**New Request for Advice - Modification 1 Revised Layout and Earthworks
(SSD-5248-Mod-1) (Fairfield City))**

TAB A - TfNSW Comments on Modification 1 Revised Layout and Earthworks (SSD-5248-Mod-1), Gazcorp Industrial Estate

Figure 4 | SSD-5248 MOD-1 Proposed Concept Plan

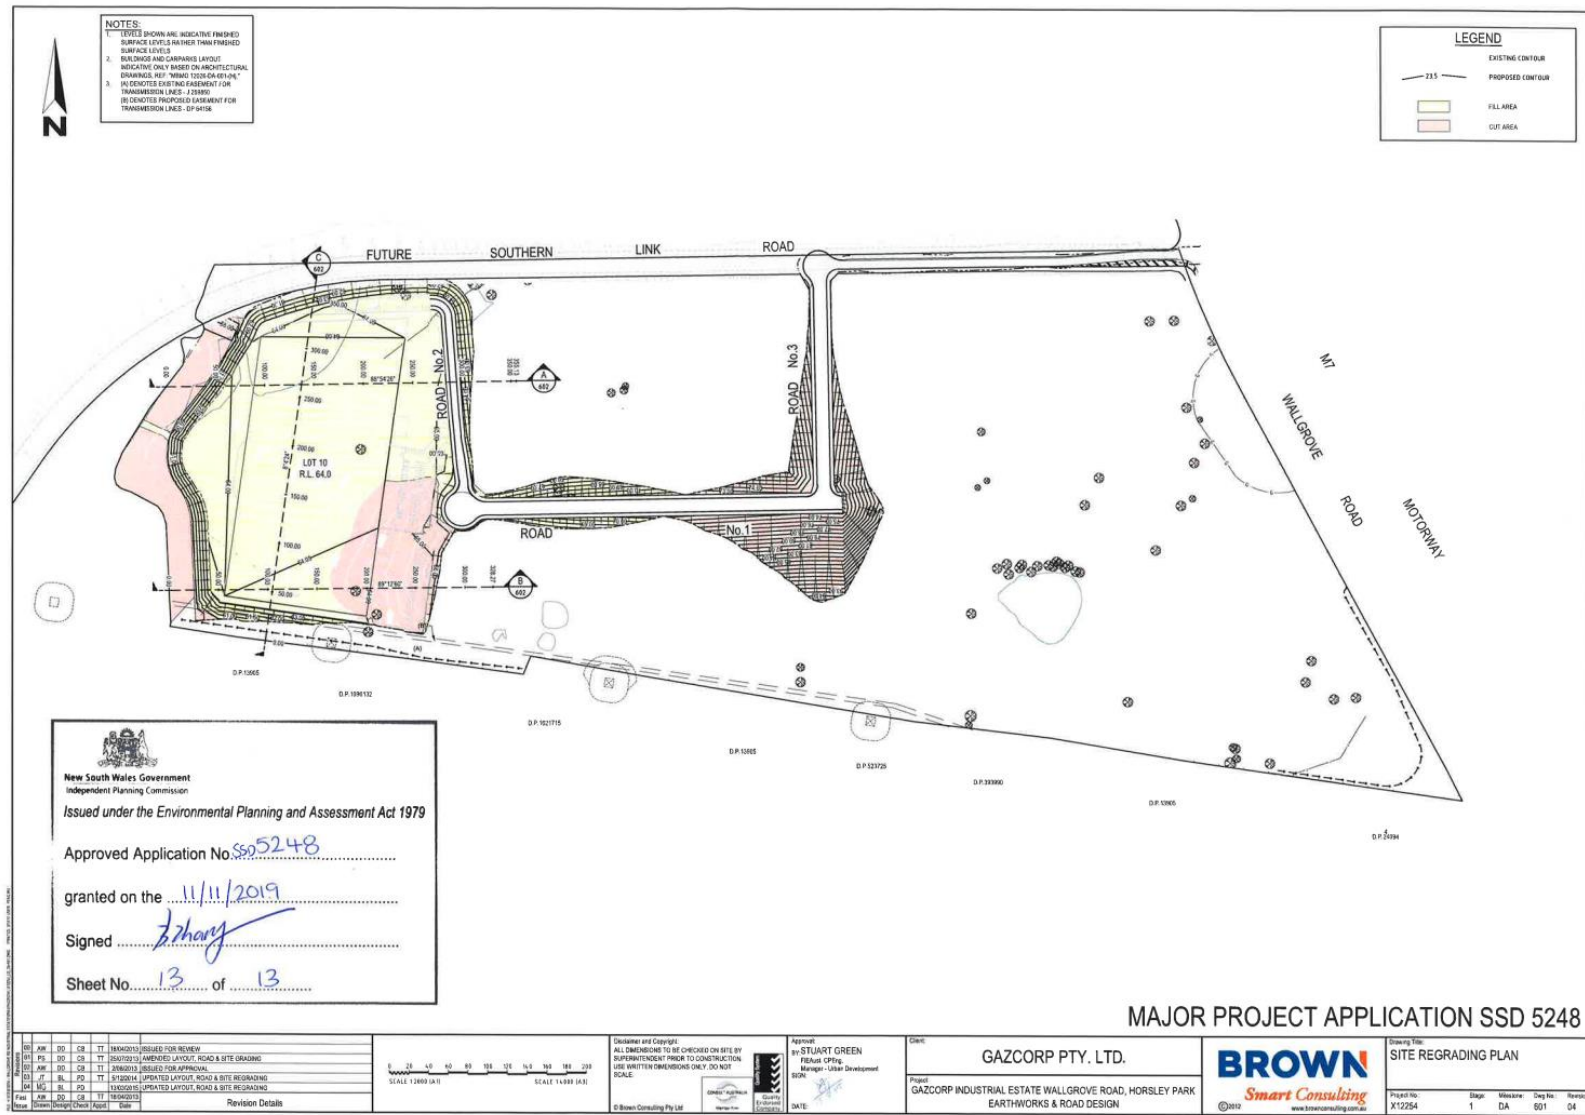
- TfNSW notes at Appendix A1 (Concept Masterplan), the Western Sydney Freight Line (WSFL) corridor is incorrectly located. On July 3, the *State Environmental Planning Policy (Major Infrastructure Corridors) 2020* was gazetted, identifying and protecting the WSFL. The GIS data for the gazetted corridor is publically available ([link](#)).

- At page 3 of the Mod 1 Report prepared by Ethos Urban and dated 12 April 2021, it incorrectly states that the WSFL corridor is located immediately south of the TransGrid easement. In fact the WSFL Corridor overlaps the TransGrid easement at this location and is in close proximity to Lot 10 Warehouse. As per the conditions of consent issued with the approval on 11 November 2019, TfNSW reiterate to the proponent the critical importance of preparing a consultation regime, as per Part C - Western Sydney Freight Line, Condition C107(b), prior to the issue of any construction certificate, to mitigate any future conflict between Lot 10 Warehouse and the future rail infrastructure. This would include ensuring any future tenant of the Lot 10 Warehouse is not adversely affected by any noise and vibration likely to emanate from the proposed infrastructure.

- It is requested that the applicant revise Appendix A1 (Concept Masterplan) to illustrate the correct position of the WSFL.
- Condition B26 requires consultation with TfNSW with respect to future development applications and potential implications on the WSFL. The proponent should consult with TfNSW early in the design of the warehouse on Lot 10.
- No changes to conditions B26, C9 or C107 of the existing consent should be contemplated.
